Our ref: OUT26/2115

Subject: Corrimal Coke Works – Stage 2-4 – Early Stage (Civil Works) (SSD-86131212) –
Environmental Impact Statement

Detailed advice to DPHI Planning & Assessment regarding the Corrimal Coke Works – Stage 2-4 – Early Stage (SSD-86131212) – EIS

DRAWING NUMBER MKR00452-11-C0100	SHEET No. 1 OF 3	ORIG. SIZE A1	REVISION 7
-------------------------------------	---------------------	------------------	---------------

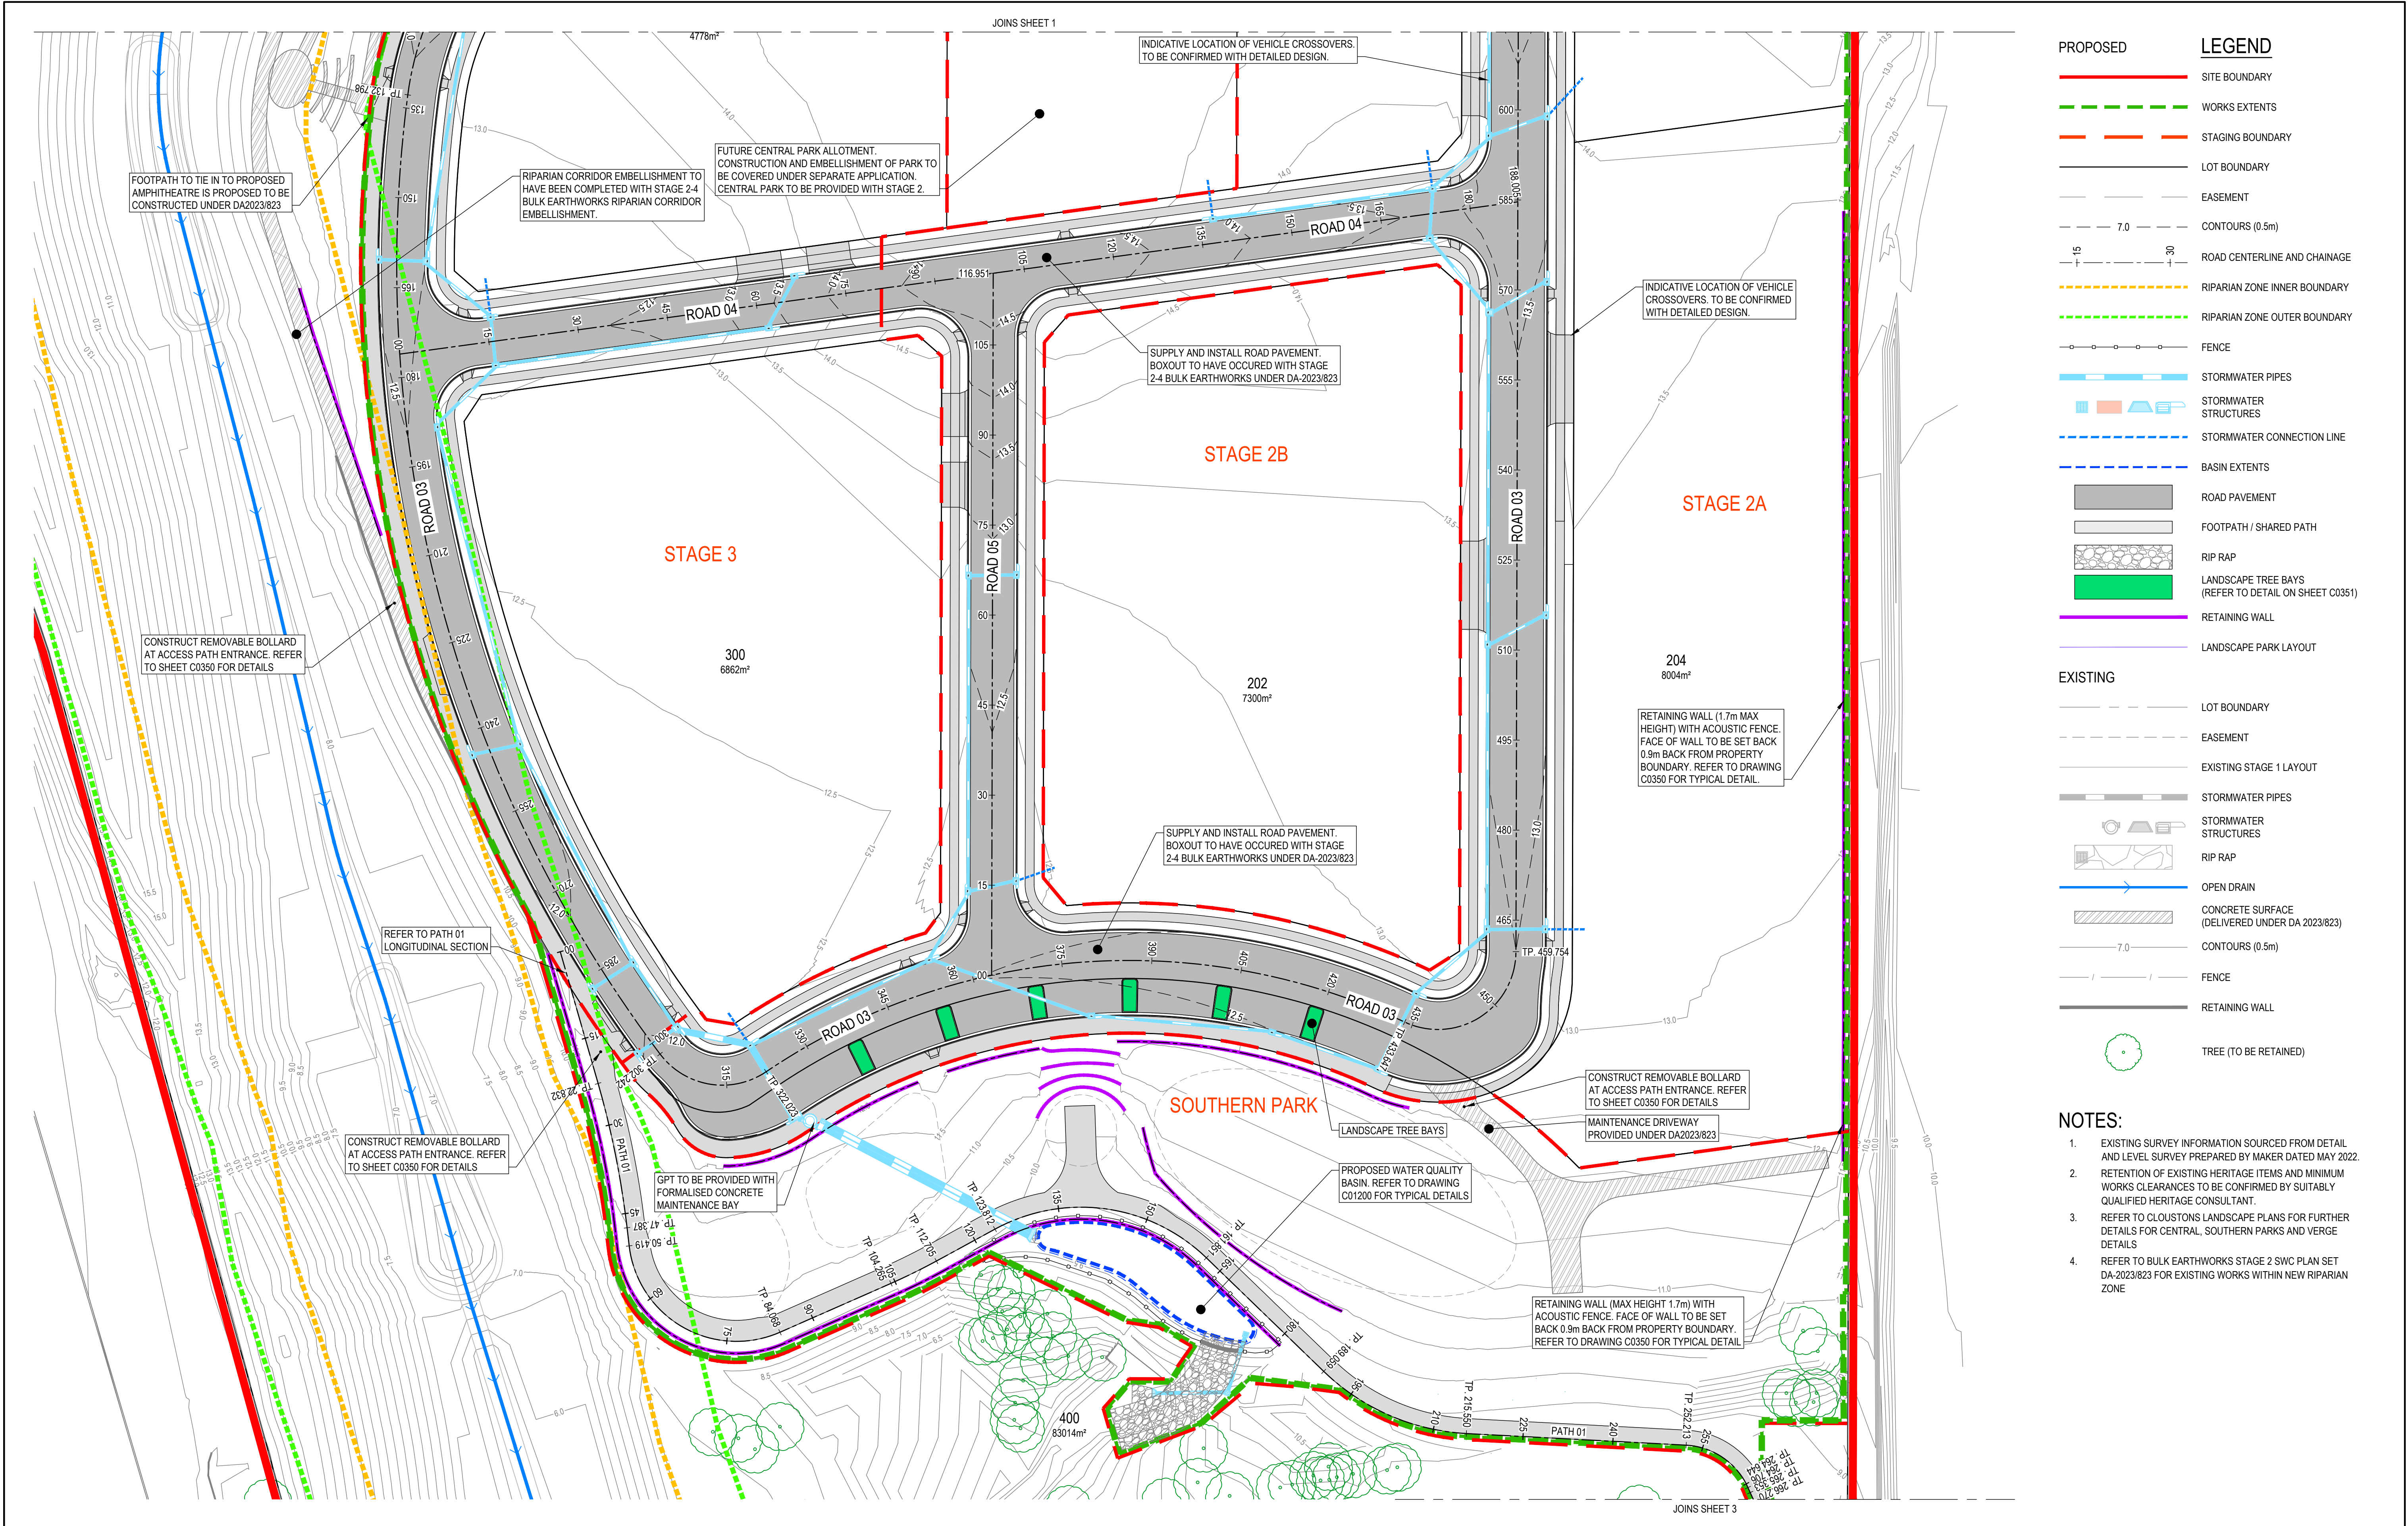
The Civil Works Plans indicate there will be encroachment into both the inner and outer vegetated riparian zone (VRZ) of the relocated North Corrimal Creek. This includes Road 03. This proposal is inconsistent with the Guidelines for Controlled Activities for Riparian Corridors.

The extent of encroachment into the VRZ is also not in accordance with the previously approved Controlled Activity Approval (CAA-2025-10427) under the Water Management Act 2000 for the watercourse realignment and associated vegetation management plan. Approved plans show the road boxing for Road 03 as outside of the required Outer VRZ and was approved with a Vegetation Management Plan with areas of revegetation required along both North Corrimal Creek and Towradgi Creek. It is recommended this project be reviewed for consistency with the approved CAA.

- Revise the layout to remove works from the vegetated riparian zone of North Corrimal Creek.
- Review the project for consistency with current Controlled Activity Approval issued for the site under the *Water Management Act 2000*.
